DECISION DELEGATED TO HEAD OF PLANNING

Application No: H16-0690-21 **Applicant:** Aldrich Group
Proposal: Demolition of Station House and erection of 6 self contained flats
Location: Station House Kings Road Spalding
Terminal Date: 30th September 2021

Drawing Number:	A1543-10	Rev:	-
-----------------	-----------------	------	----------

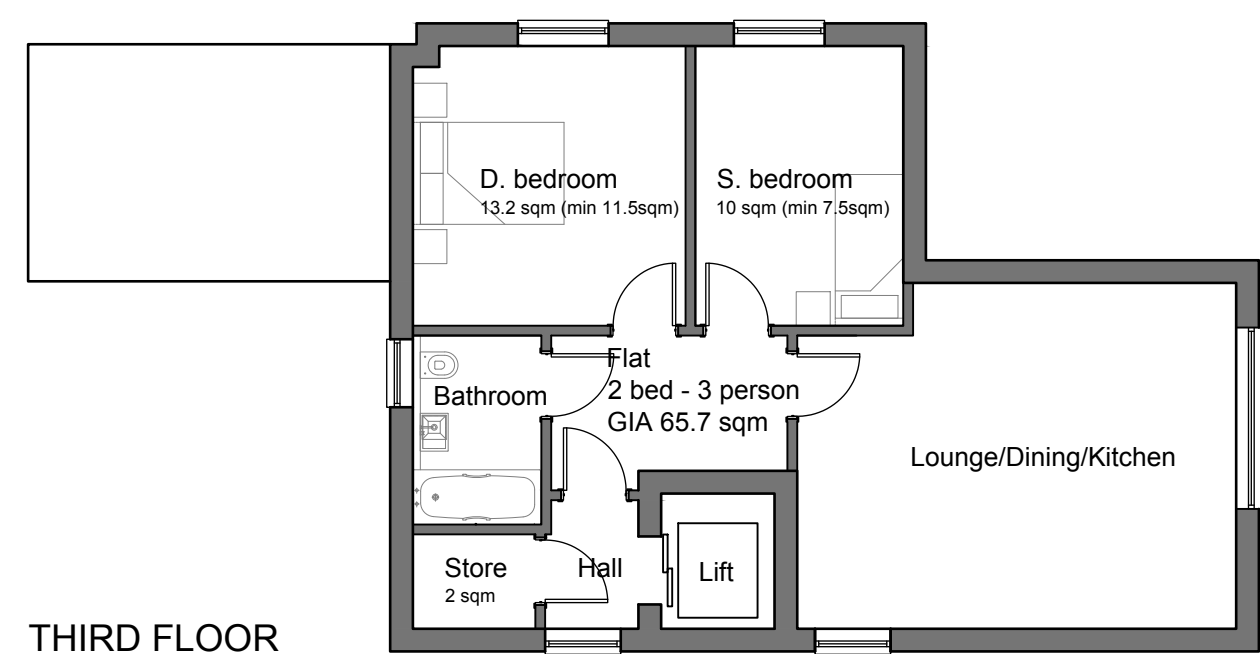
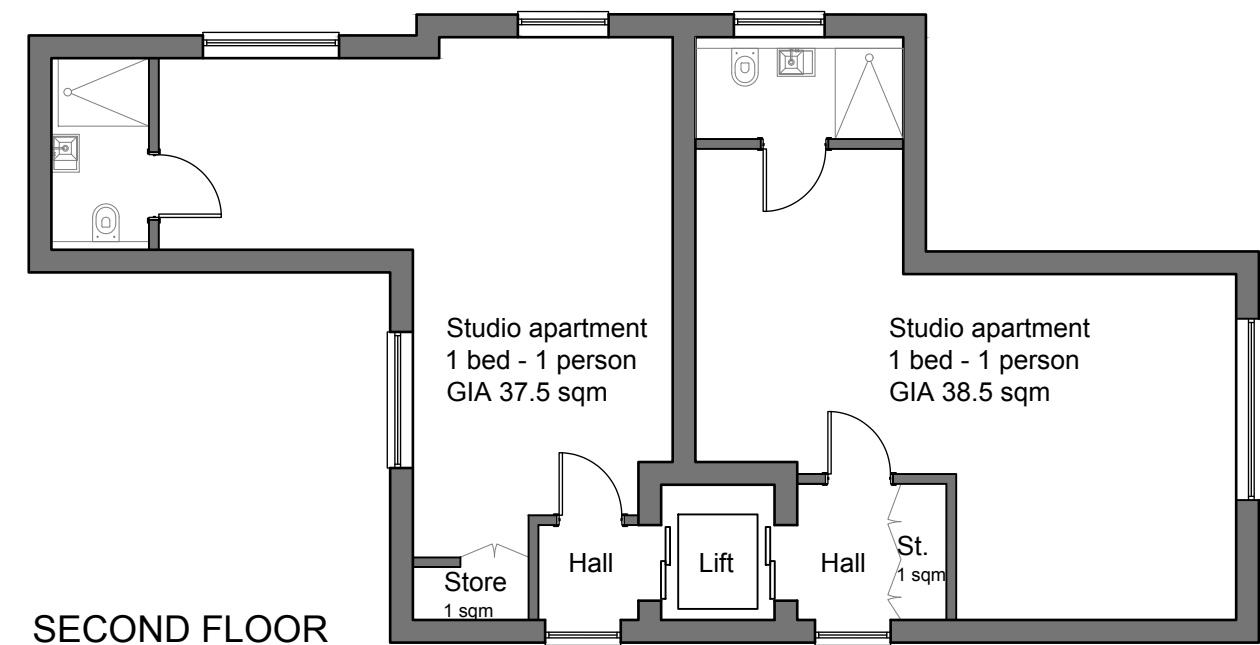
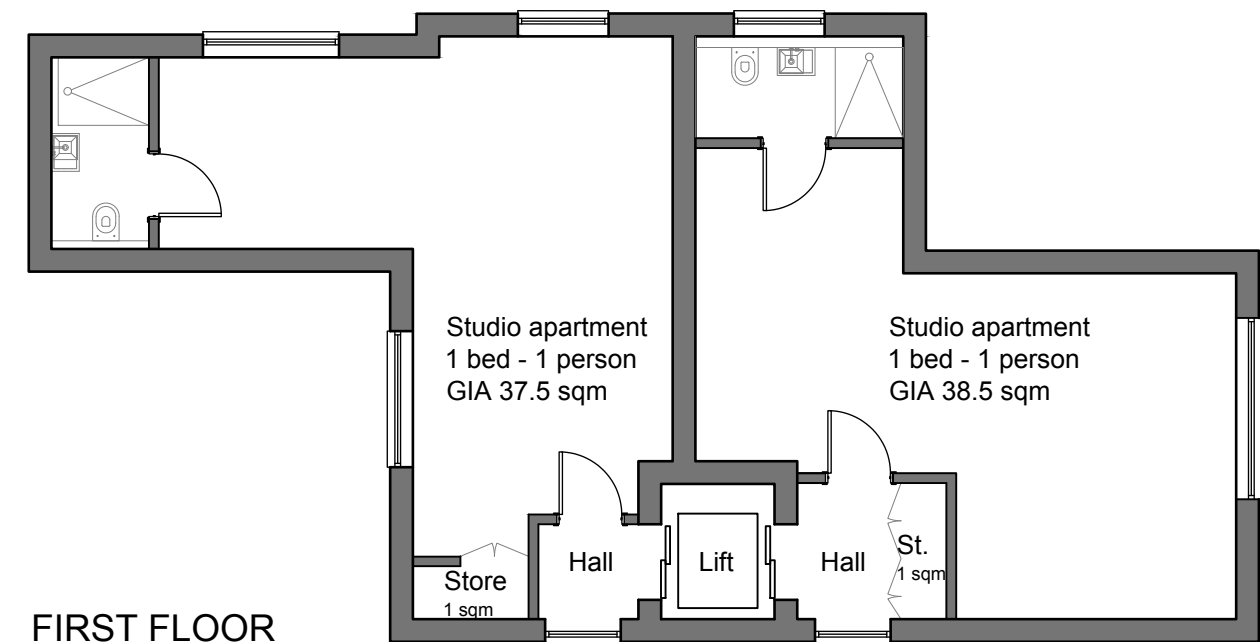
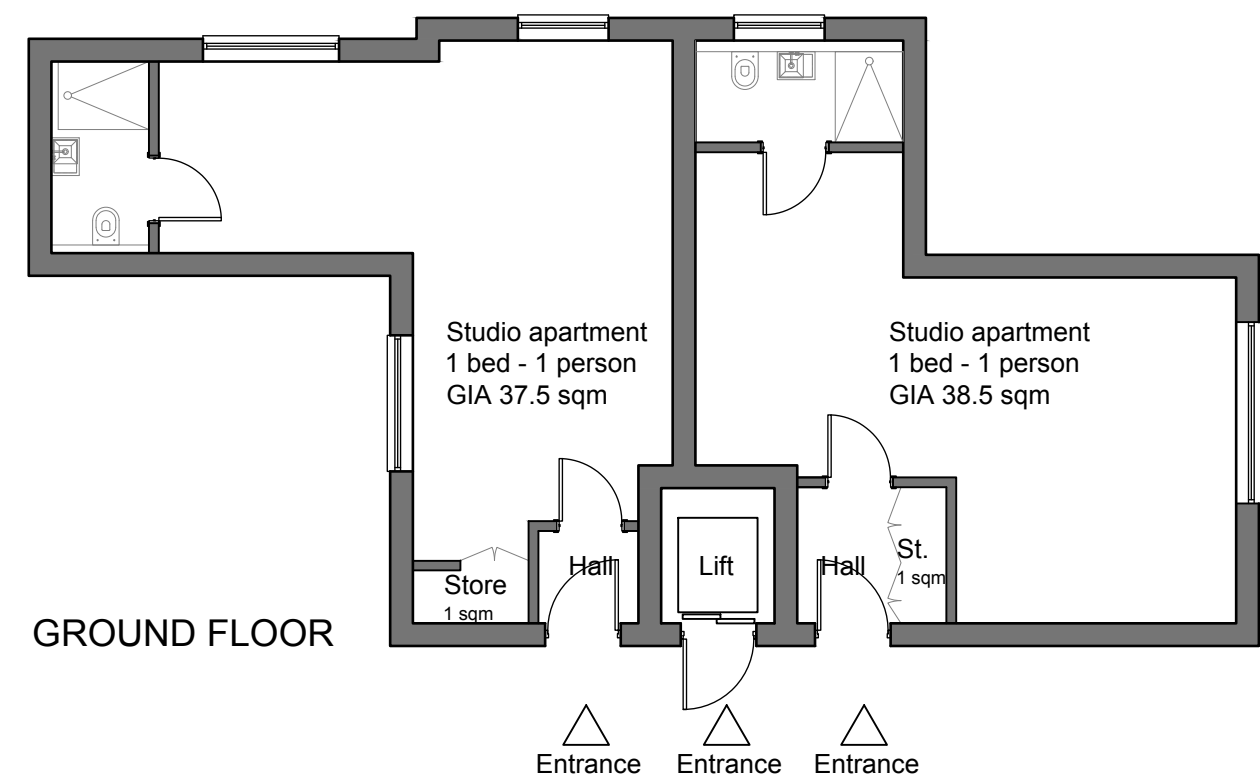
(d) During the course of the application, discussions have taken place regarding the design of the building, which was originally proposed to be four storeys in height, flat roofed and feature rendered and buff brick elements, at odds with existing development in the vicinity. Revised plans have since

been submitted for a three storey building of red brick construction with the incorporation of features such as stone lintels, decorate bargeboards and finials and a pitched roof in an attempt to provide some reference to the existing building. Taking into account existing development in the vicinity, the revised design/appearance is now considered appropriate for the site.
